Our Ref: 0394A

Your Ref: SSD - 93020230

**OBJECTION TO SSD 93020230 40-48 REDAN STREET, MOSMAN
PROPOSED DEMOLITION WORKS AND CONSTRUCTION OF A PART 10-STOREY AND
PART 5-STOREY PROPOSED RESIDENTIAL FLAT BUILDING CONTAINING 53
RESIDENTIAL DWELLINGS (INCLUDING 11 AFFORDABLE HOUSING UNITS) WITH 2
LEVELS OF BASEMENT PARKING CONTAINING 106 RESIDENT PARKING SPACES
APPLICANT: MOSMAN LAND NO. 1 PTY LTD**

Figure 7 Correct Measurement of Green Line in Figure 13 of TIA relied upon by the EIS

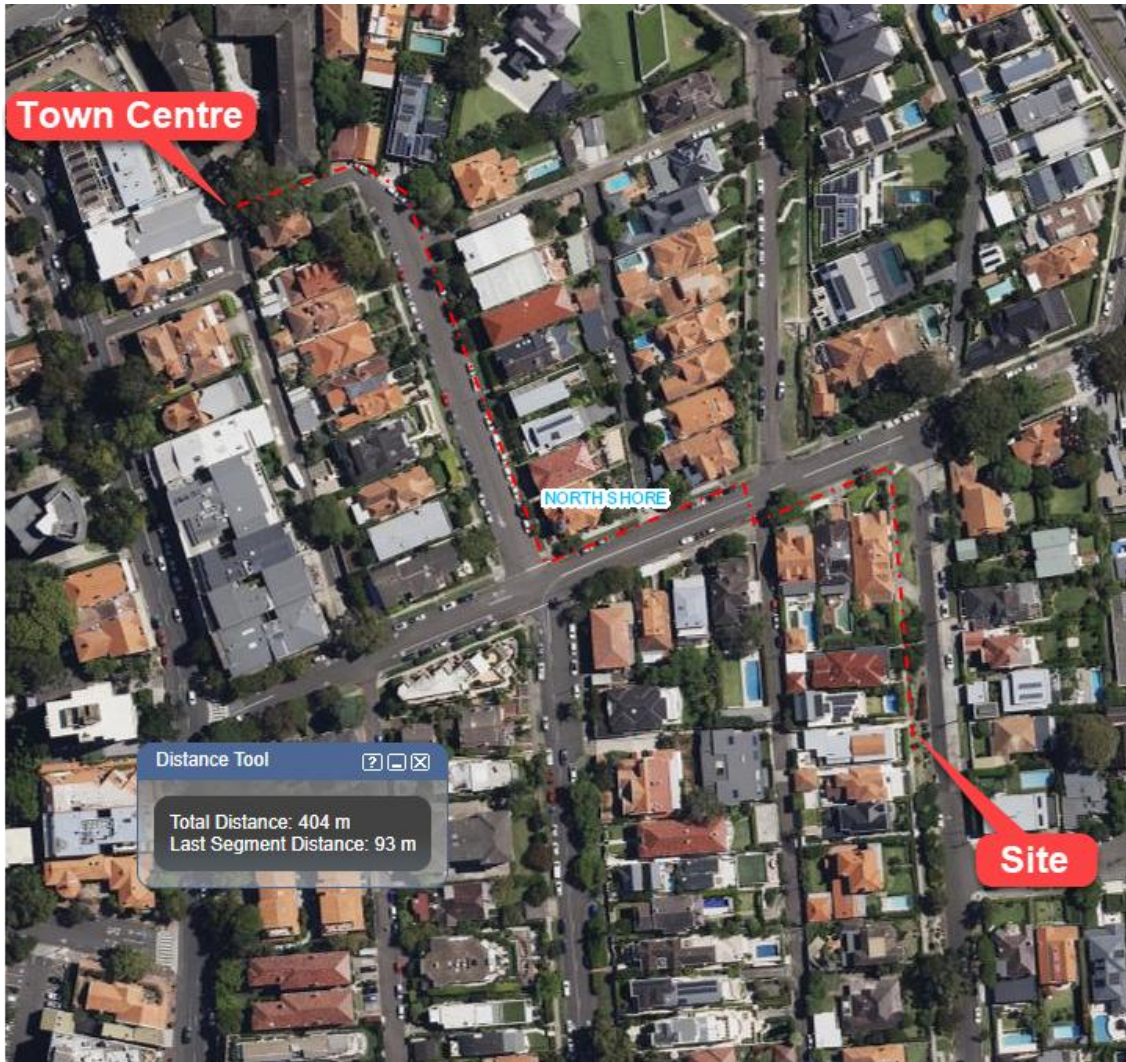
JMT Consulting describes the route in the TIA and states '*As advised by LTS Surveyors this walking route has a total distance of 394.7m to the nearest 0.1m.*' Although the walking route assessment in the TIA does not rely upon Redan Lane, the measurement of 394.7m is incorrect as the correct measurement of the green line in Figure 13 of the TIA is 404m (**Figure 7**).

Although the TIA does not purport to rely upon Redan Lane as part of any walking route, the EIS nevertheless appears to rely upon an incorrect measurement of 394.7 metres, which has been used to falsely characterise the site as falling within a 'low and mid rise housing inner area' (as defined).

Figure 9 Spit Junction Town Centres map – Extract with SPS Mark-up in Red

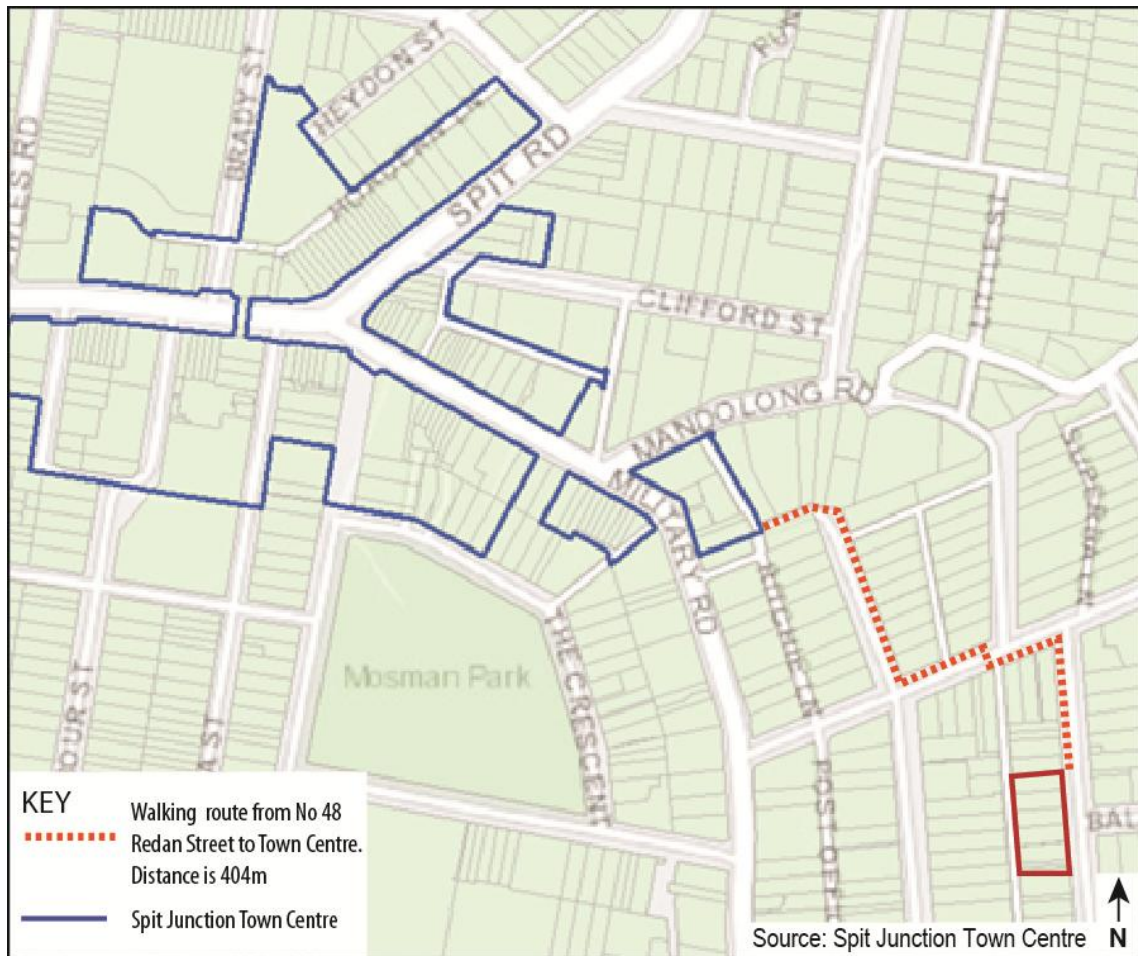
Figure 9 indicates an extract from the ‘town centres map’ which identifies Spit Junction Town Centre relative to the location of the subject site.

Whilst the site is within a low and mid rise housing area, it exceeds 400m 'walking distance' of the Spit Junction Town Centre and therefore is appropriately categorised as a low and mid rise housing outer area.

Even without using the available pedestrian crossing and by disregarding slope, the site is measured well in excess of 400m from the edge of the nominated Spit Junction Town Centre via the footpaths that can be safely walked by a pedestrian to the Redan Street frontage.

Figure 10 – The Mosman LEP 'Scenic Protection Area' bisects the site. (Source: MLEP 2012)

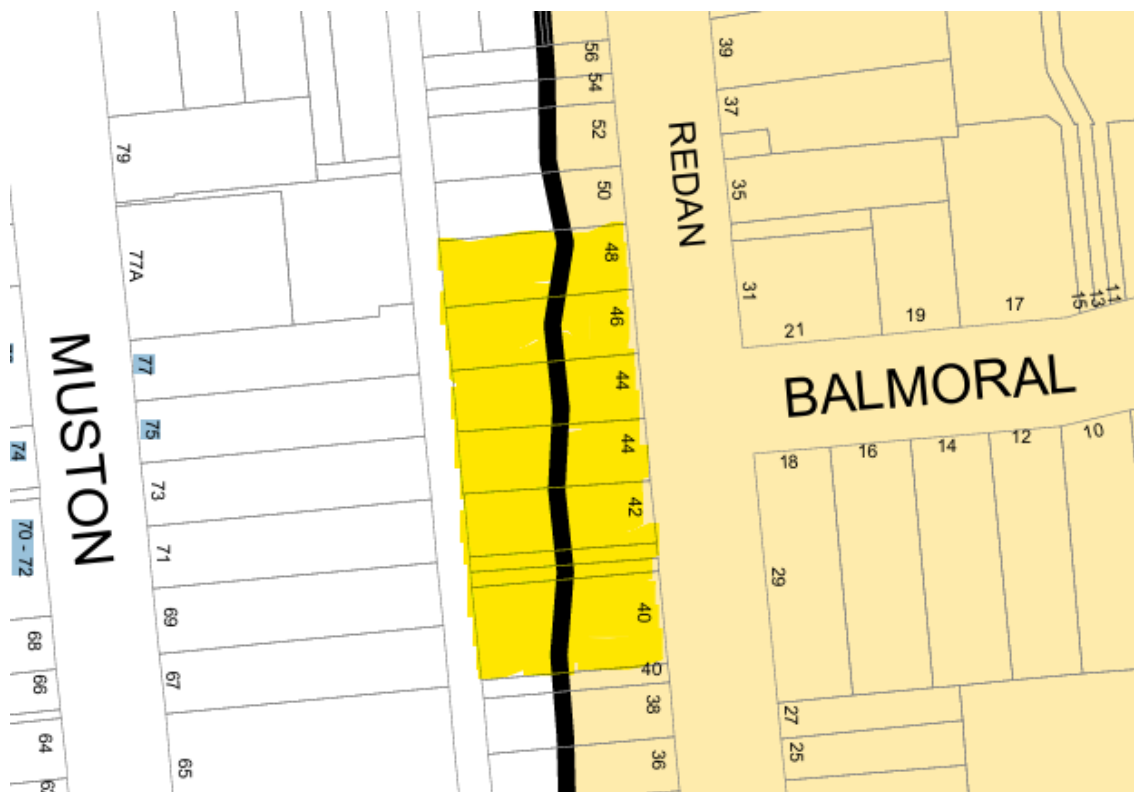
2. Inadequate R3 Medium Density Residential / C4 Environmental Living Zone Transition and Adverse Impact on Scenic Protection Area
